Our Ref: FG/166/18/HH

**Town & Country Planning Act 1990 (as amended)
Town & country Planning (Development Management Procedure) (England) Order 2015
Application for Planning Permission for Works or Extension to a Dwelling**

Development Demolition of rear sun room & erection of single & two storey extensions, replacement front elevation porch & garage extension & replacement of existing flat roof with pitched roof over existing two storey, north-west accommodation.

Location 31 South Drive Ferring

Existing Ground Floor Plan

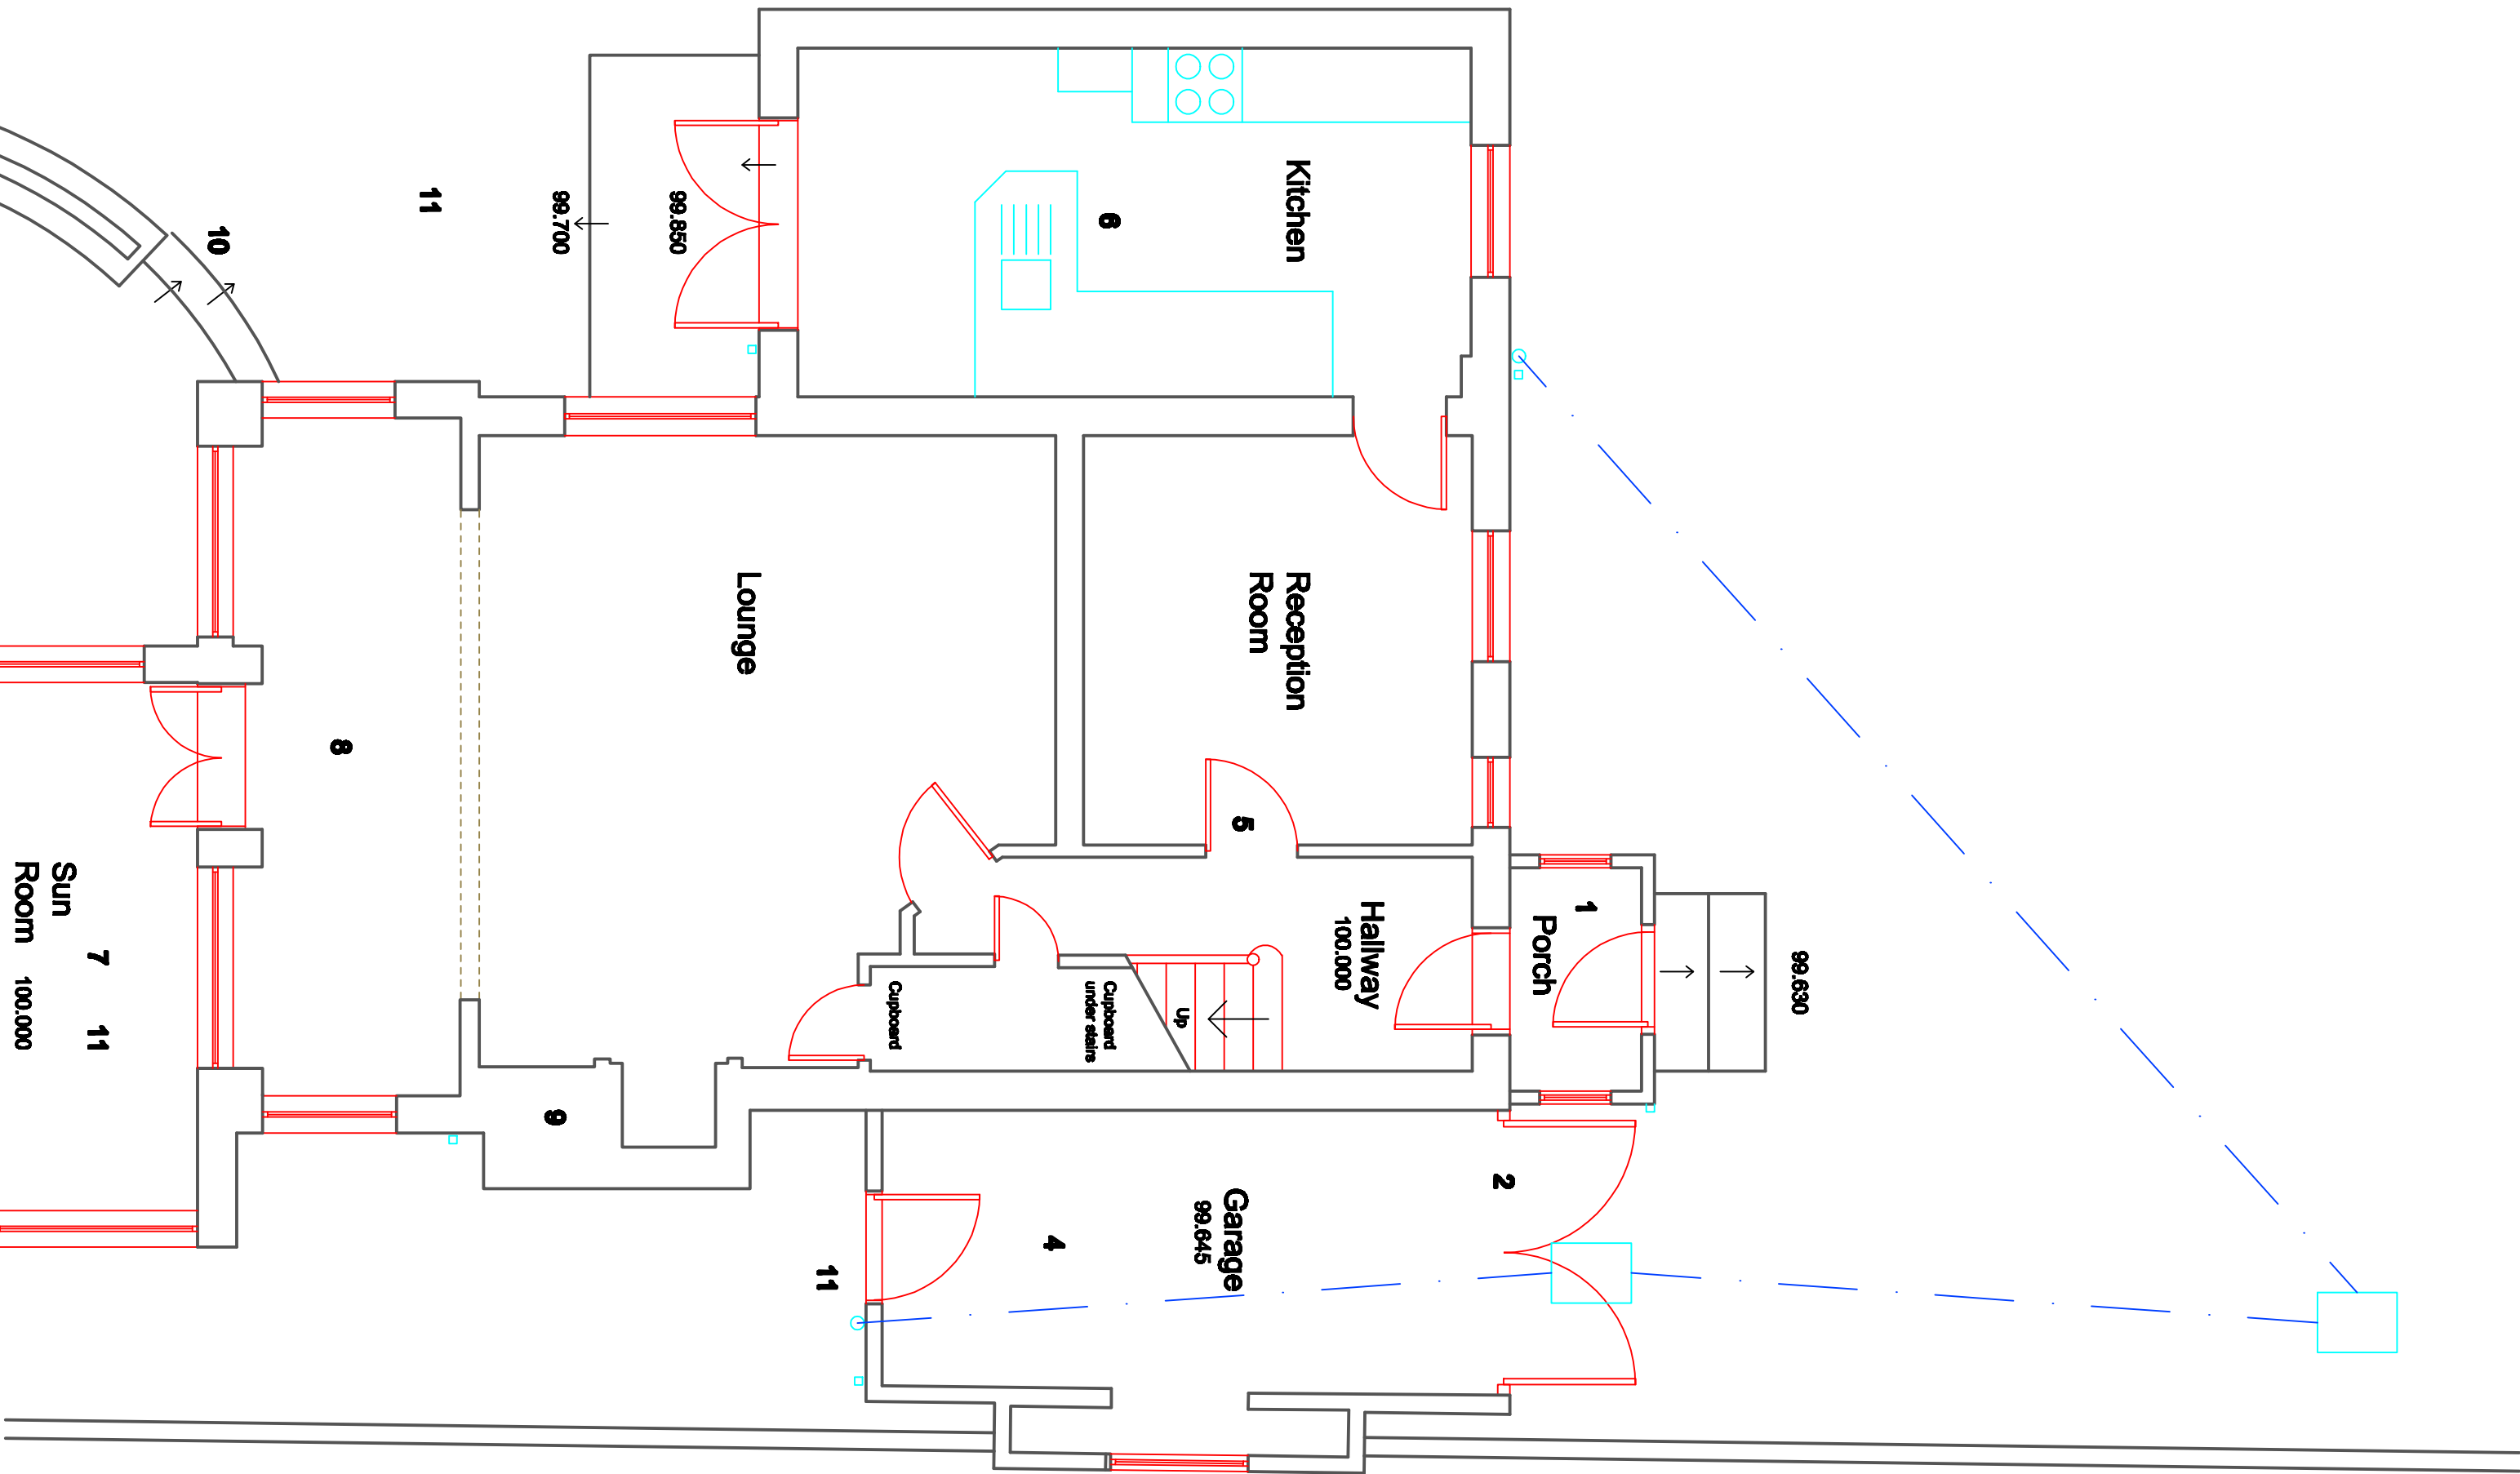
The existing ground floor plan and west elevation do not accord. Please amend accordingly.
Flood Risk Assessment
